Engineers Comments Regarding Surface Water Drainage

Application Reference:	WA/57/26/DOC	Reviewer Reference:	ADC/EXT5/AF
Planning Officer:	Amber Willard	Date of Review:	28/08/2026
Site Name:	Walberton Farm Yapton Lane Walberton BN18 0AS		
Application Description:	Approval of details reserved by condition under WA/95/24/PL relating to conditions 3- Foul Sewerage and 4- Surface Water Drainage .		
Assessment Number:	2

Application Reference: WA/57/26/DOC Site Name: Walberton Farm Yapton Lane Walberton BN18 0AS	Initial Issue Date: 31/07/2026 Issue Date: 28/08/2026 Reviewer Reference: ADC/EXT5/AF
---	---

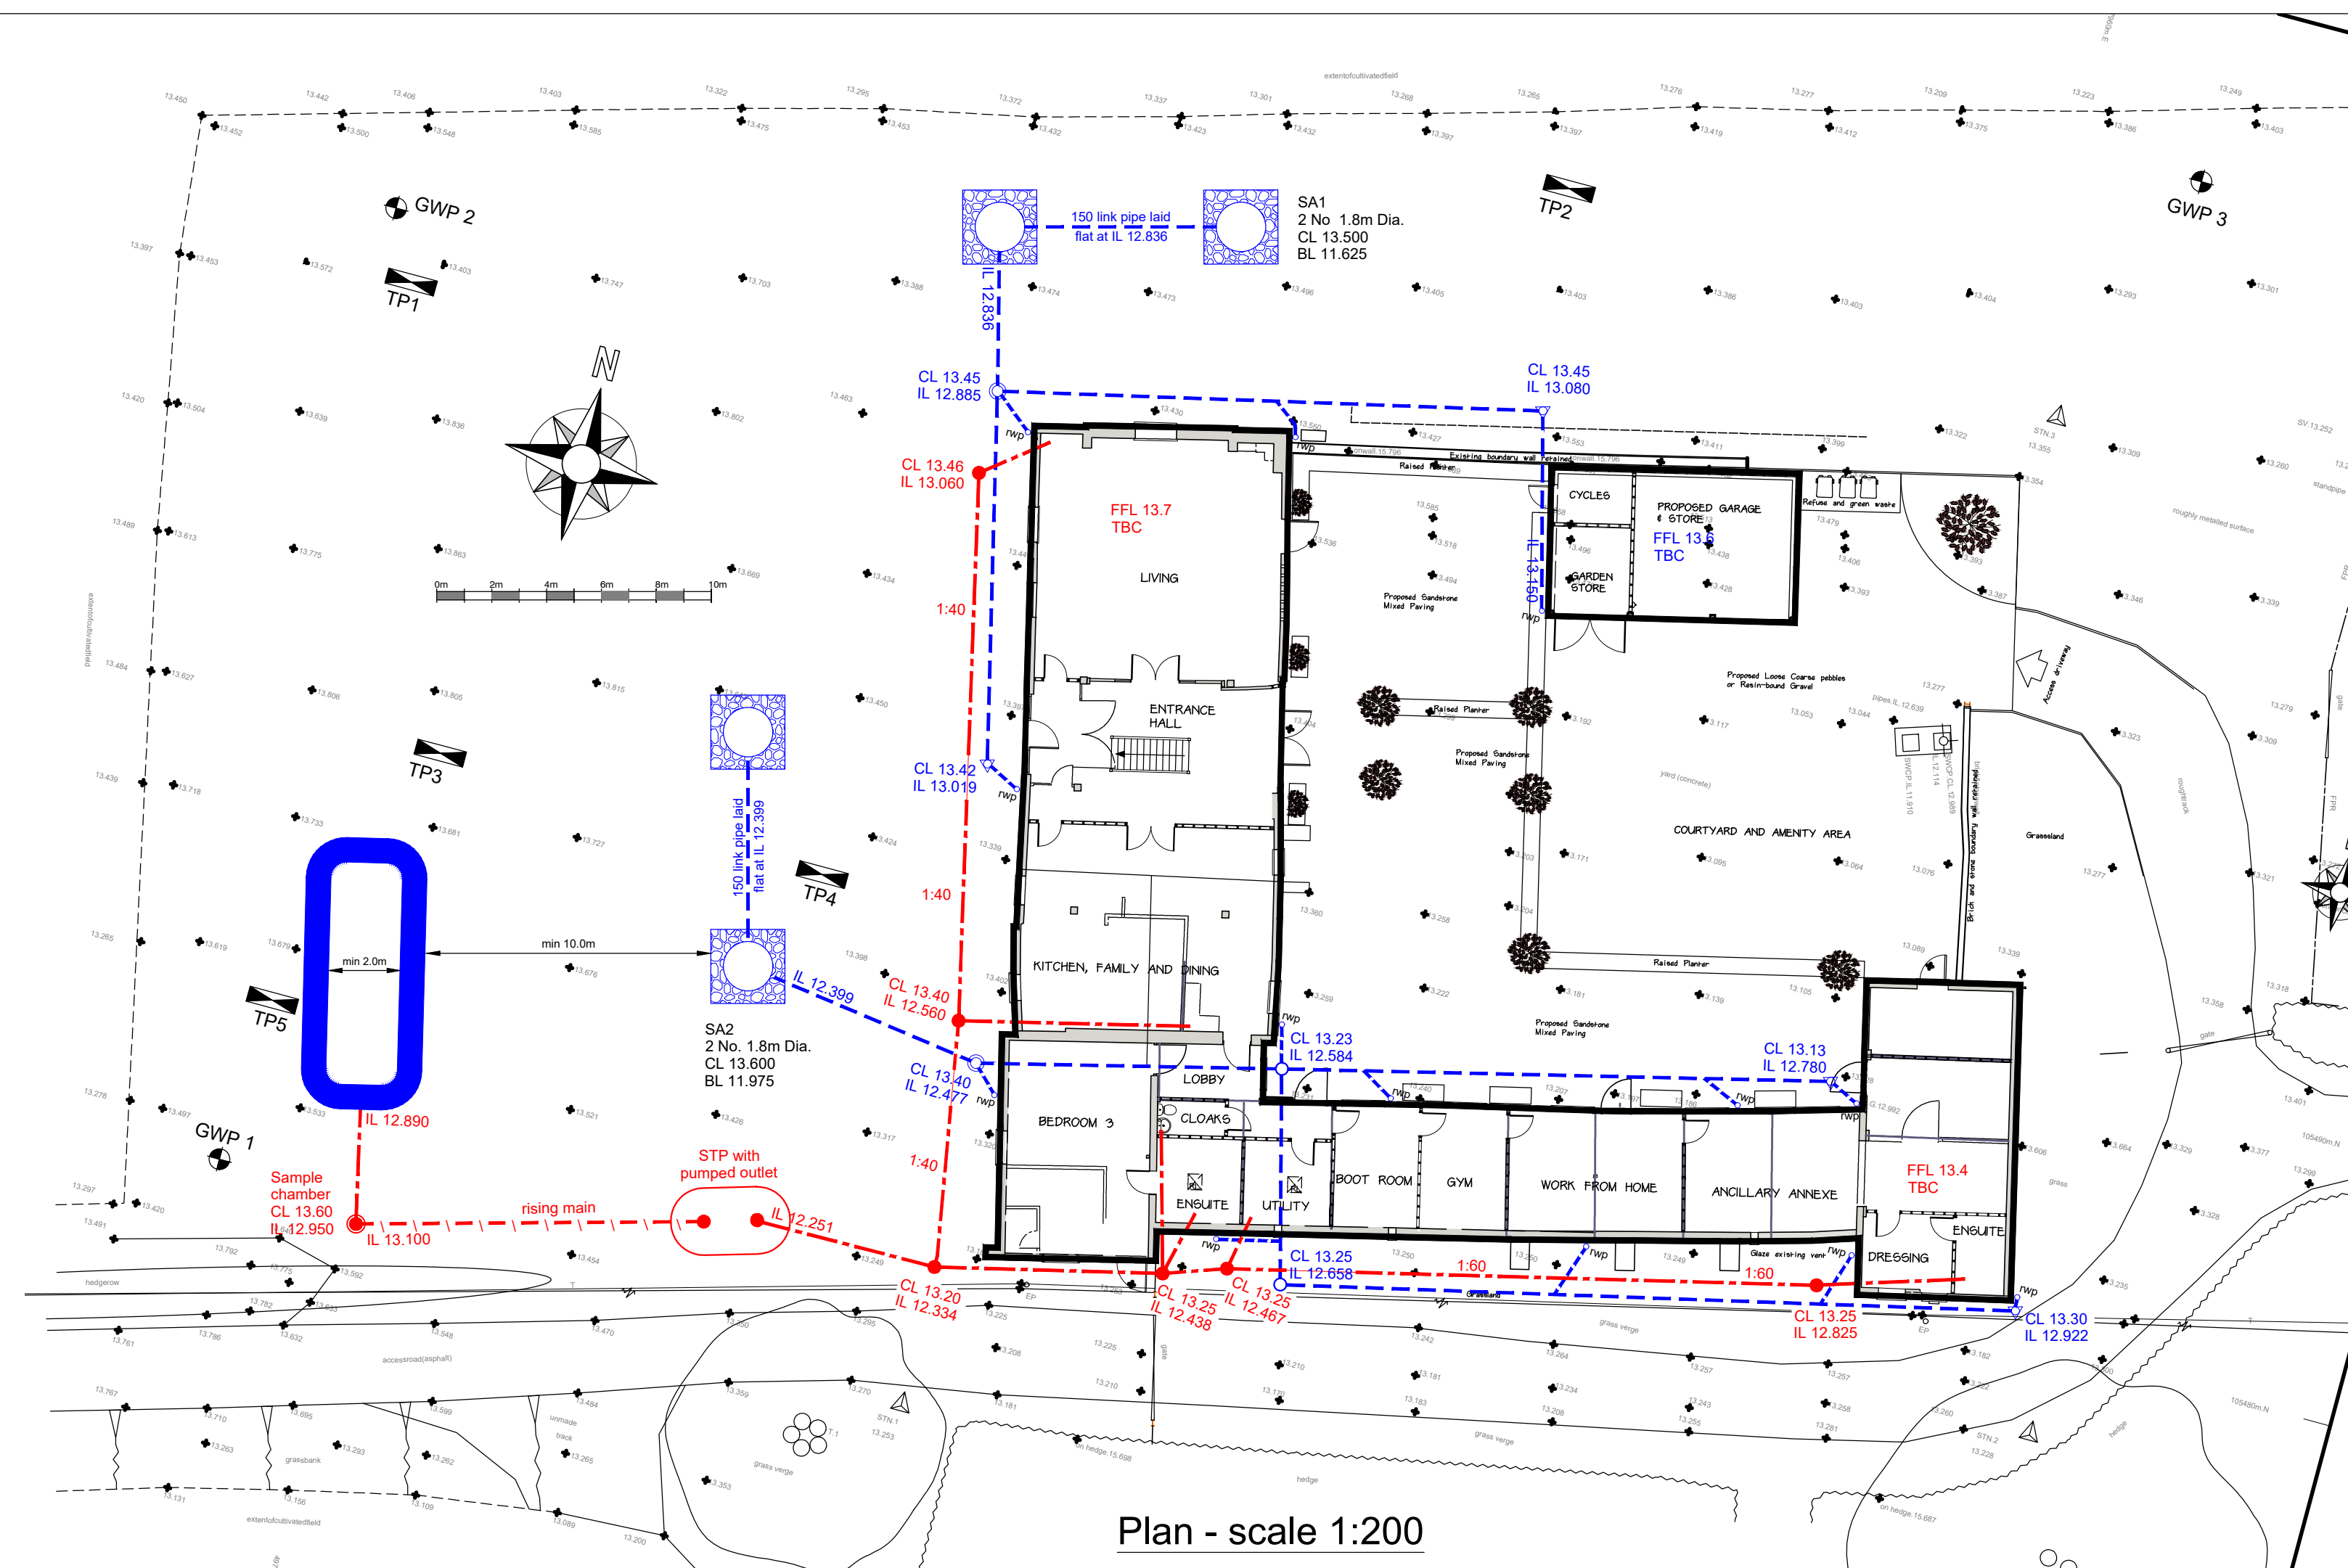
2.	The foul water drainage field should be moved to be 10m away from the surface water soakaways to separate infiltration zones.	The Drainage Layout Drawing has been updated to re-site the foul water drainage field to a distance of 10 metres minimum away from the surface water soakaways to separate infiltration zones. A note has been added to the drawing to reflect this.	Comment closed.

Impermeable areas plan Scale 1:500

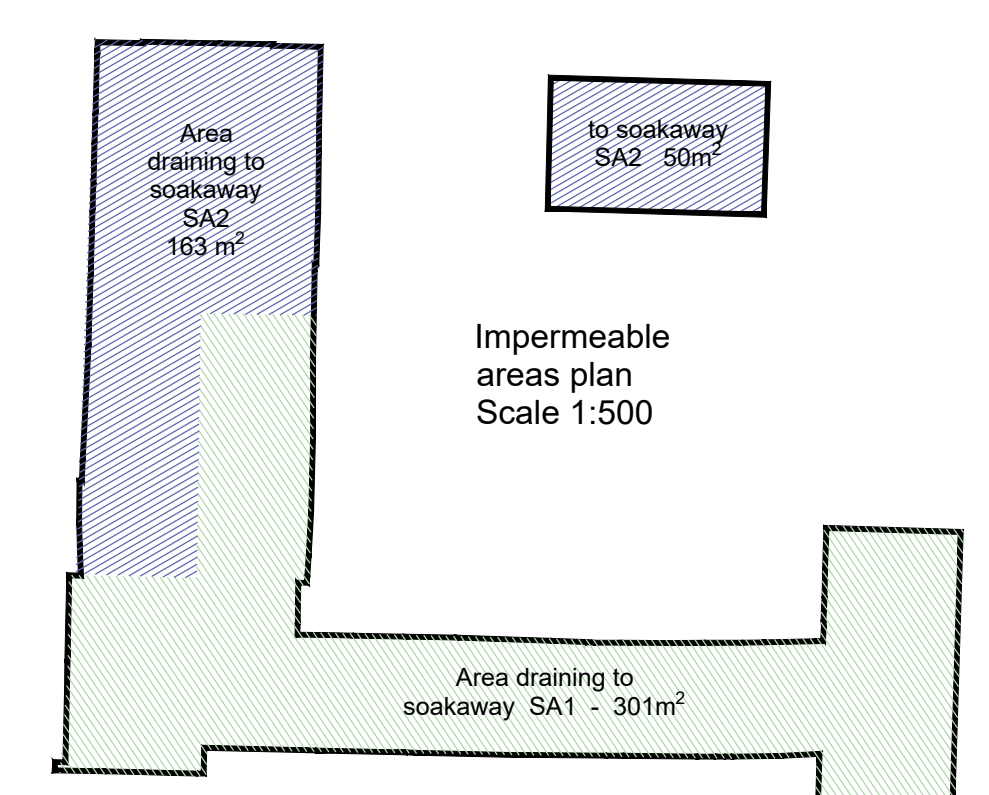
3.	An impermeable areas plan is required by the condition to verify the calculations.	An impermeable areas section has been added to the Drainage Layout Drawing indicating which sections of the roof areas, and their actual area metres ² , drain to which infiltration structures. Each of the two actual roof areas has had the Urban Creep Allowance of +10% applied within the calculations to generate the full Contributing Impermeable Areas.	Comment closed.		
----	--	--	-----------------	--	--
